From: Amanda Scholes on behalf of Planning.Responses
Sent: 07 January 2021 11:07
To: Planning Scanning
Subject: FW: Pevensey Road, BR/277/20/DOC

Please upload the below to the above application; Drainage Engineers comments.

From: Laura Gibbons <laura.gibbons@adur-worthing.gov.uk>
Sent: 05 January 2021 08:39
To: Elvin Gomery [REDACTED]
Cc: Stuart Bone [REDACTED]; Maria Tomalova <Maria.Tomalova@arun.gov.uk>
Subject: Re: Pevensey Road

POLYPIPE CATCHPIT INSPECTION CHAMBER
INCORPORATING FLOW CONTROL AND DEBRIS DEVICE

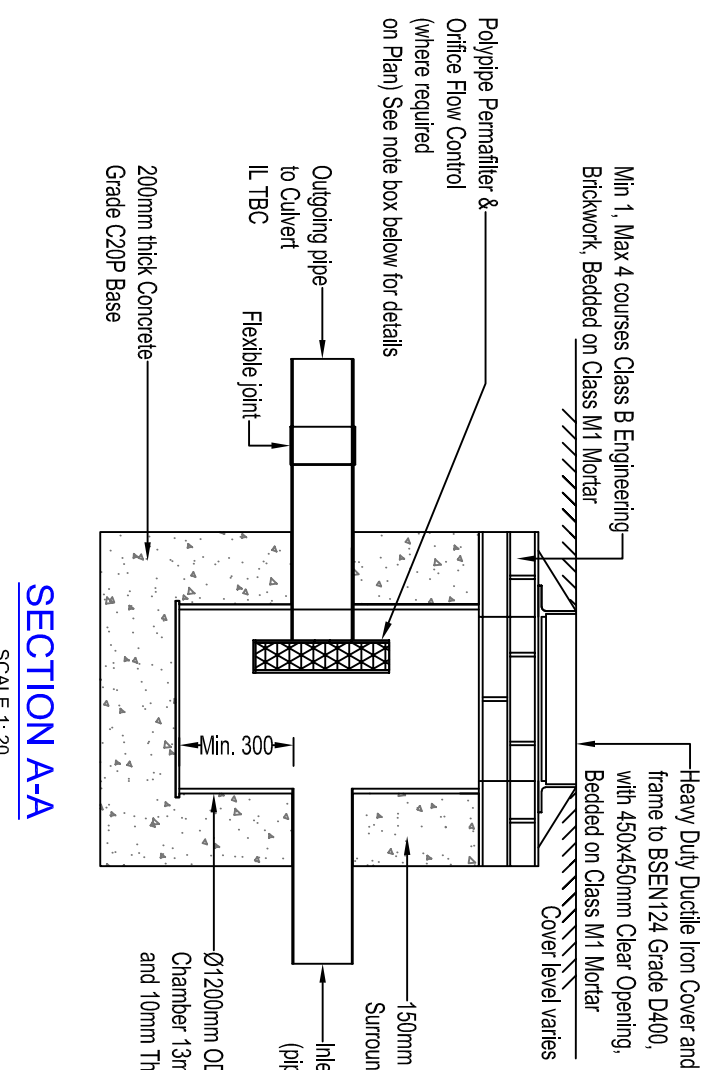
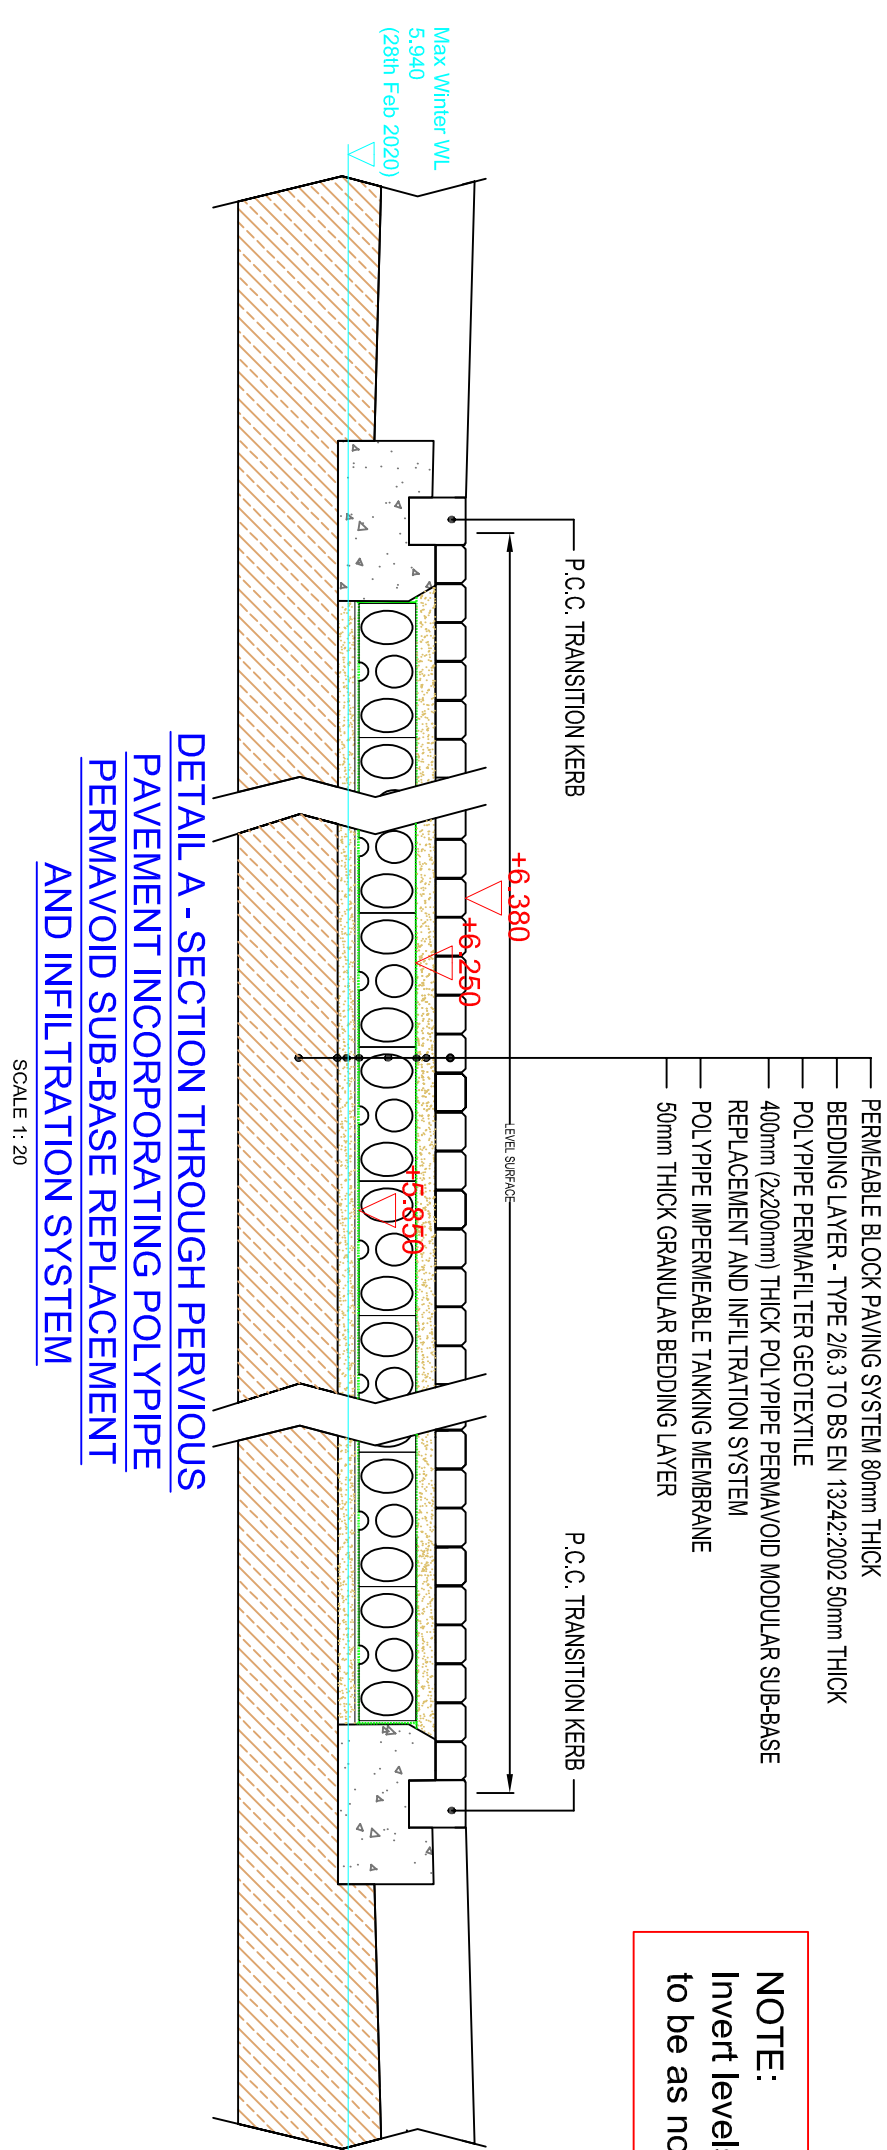
6. The invert level, cover level and unit reference of the hydrobrake must be referenced on both the plan and construction detail drawings and be consistent with that in calculations. See this has been added to the drawing *Unit reference now okay on detail, please add invert and cover level. Please include invert, cover level and reference on layout drawing and remove the reference to a polypipe control.*

7. Please provide construction detail drawings which show the means of connection to and from the sub-base. These are shown on detail drawing 101P4 and are standard permavoid details. *Please add note to indicate that the invert level of connection is stated on layout, otherwise all pipes (including outlet) may be set in the middle of the storage. Which is not what you have modelled.*

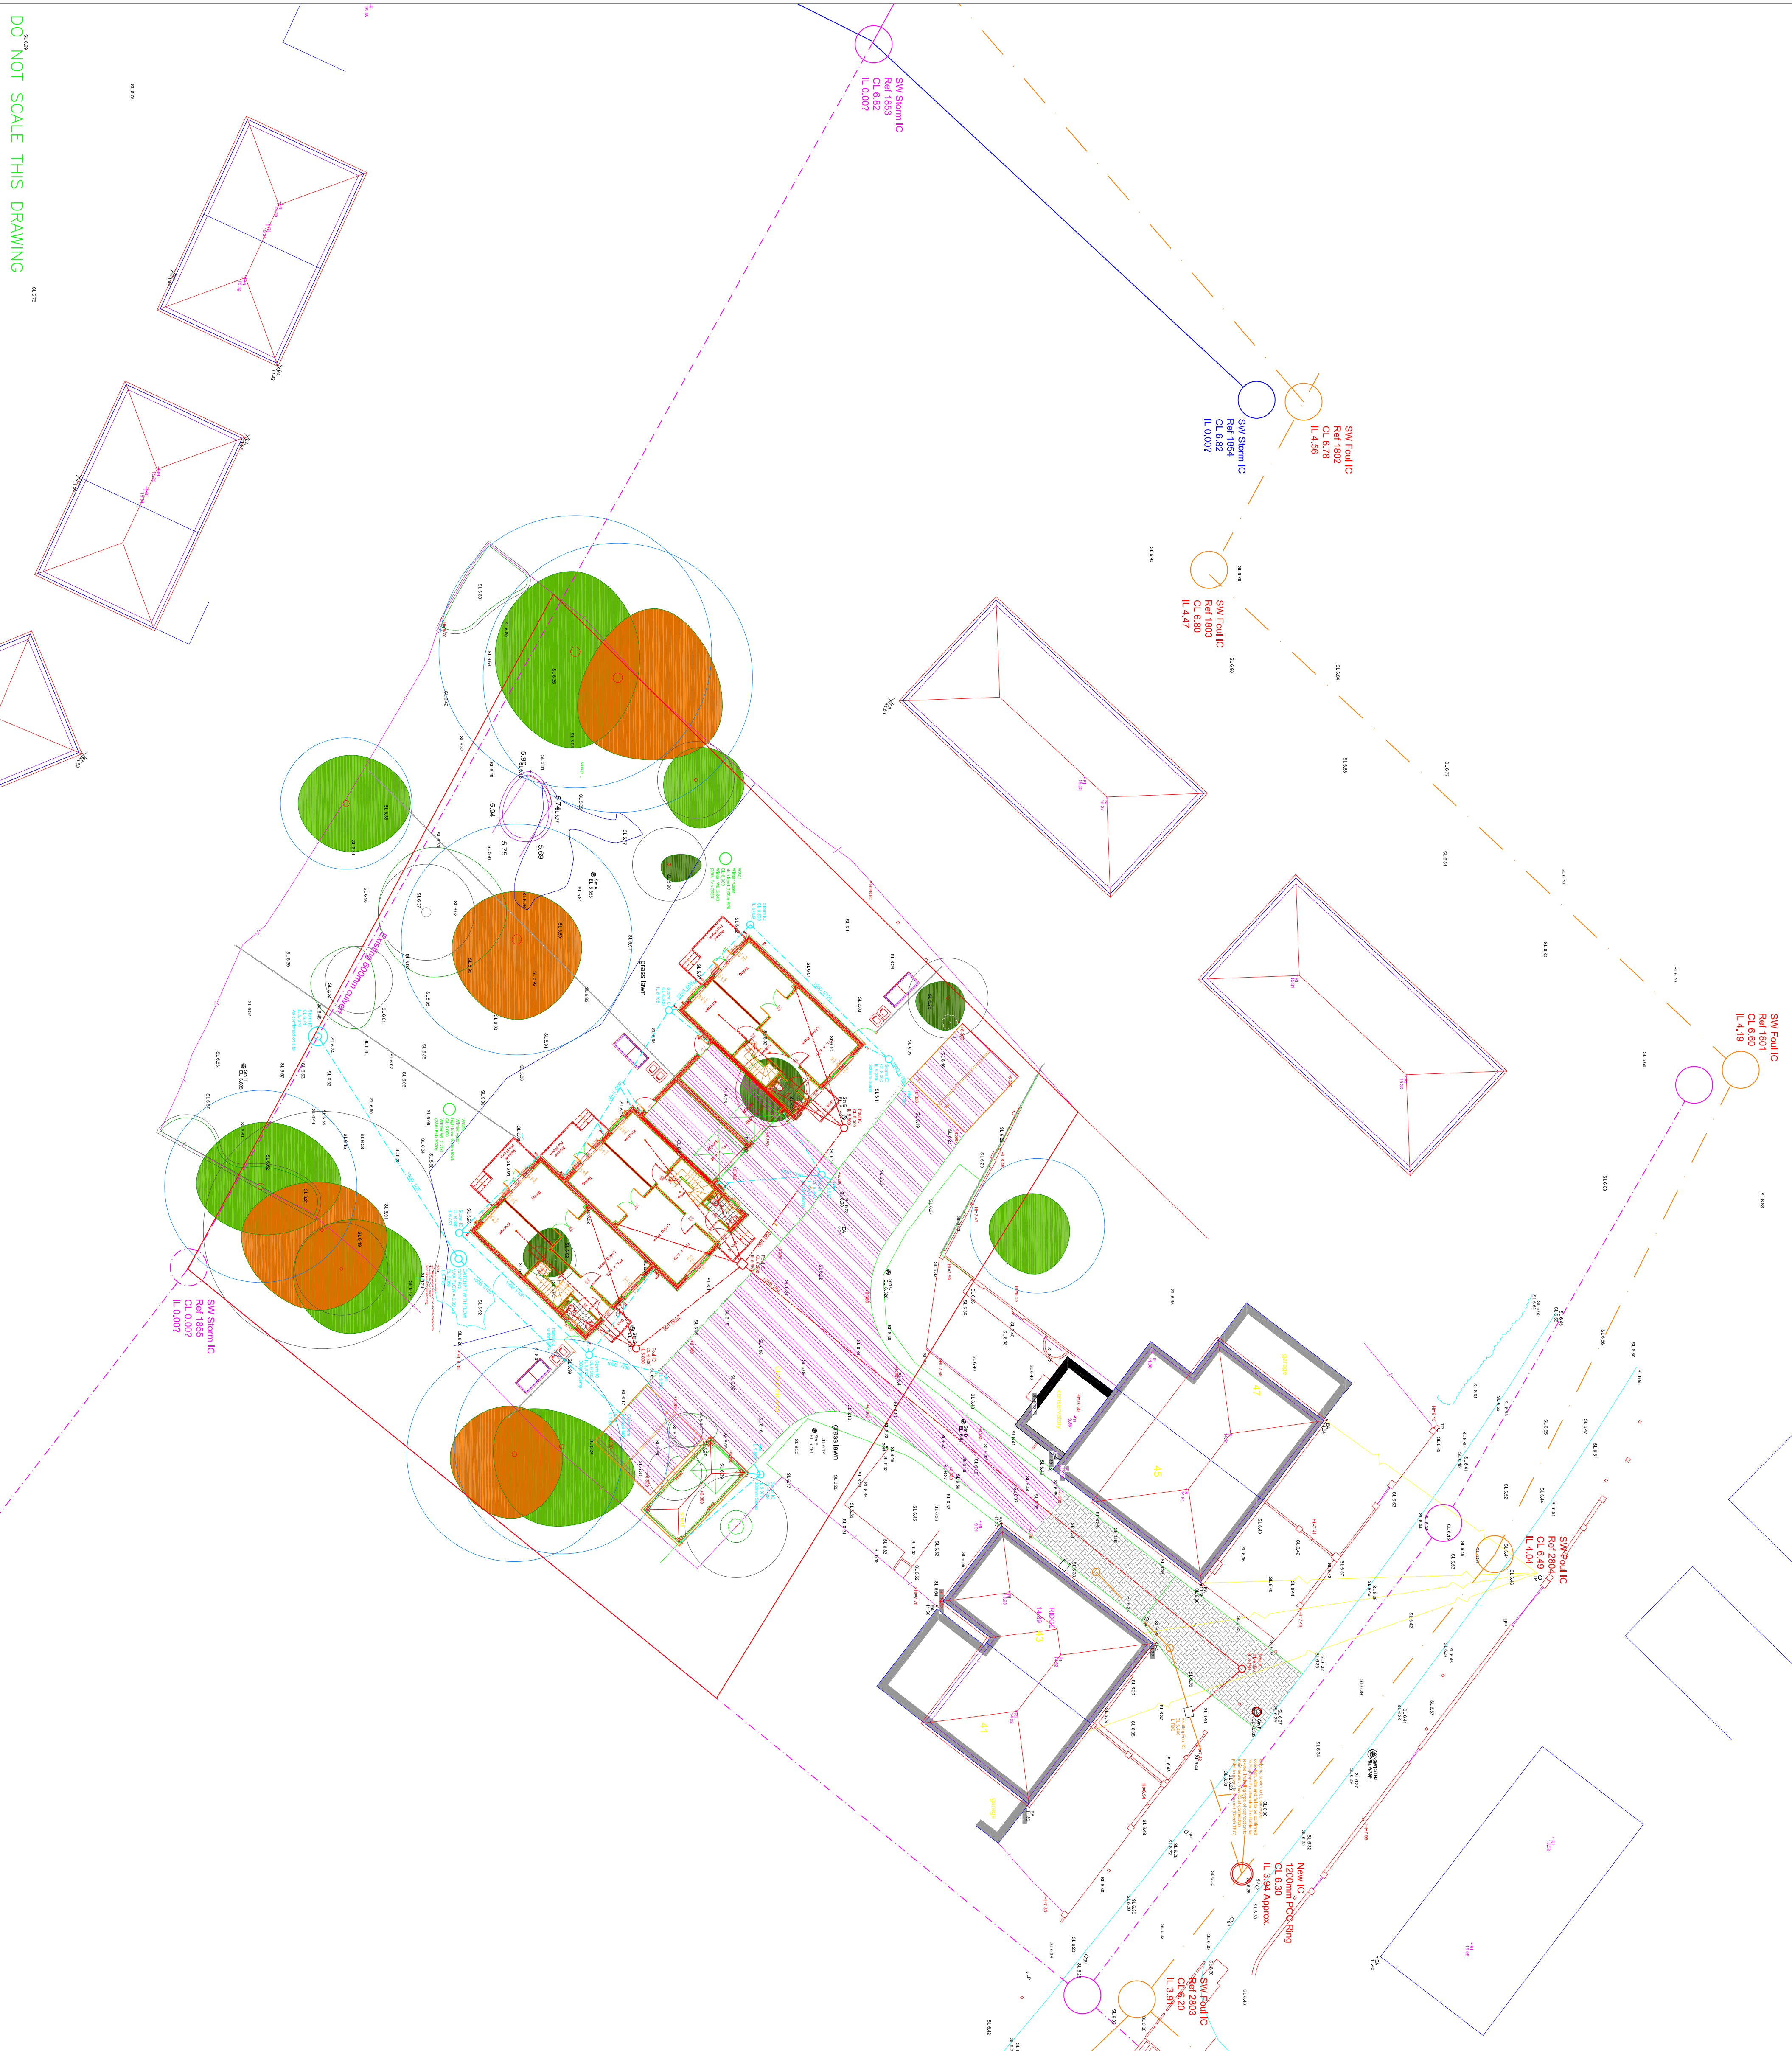
3. I note a flow through pond structure has been modelled with an area of 487m², it is presumed this has been modelled to replicate the crates under the permeable paving. *Correct Please confirm this area is provided on the drawing. Yes correct but a set area of 106.4m³ storage has been set i the model. Ideally please supply the drawing in dwg format to enable independent paperless verification. Attached as requested okay.*

5. I note that the invert level of the outlet is 5.8m, yet the base level of the storage is 5.85. Please detail how this is going to work. *Adjusted to 5.85 Please adjust on drawing.*
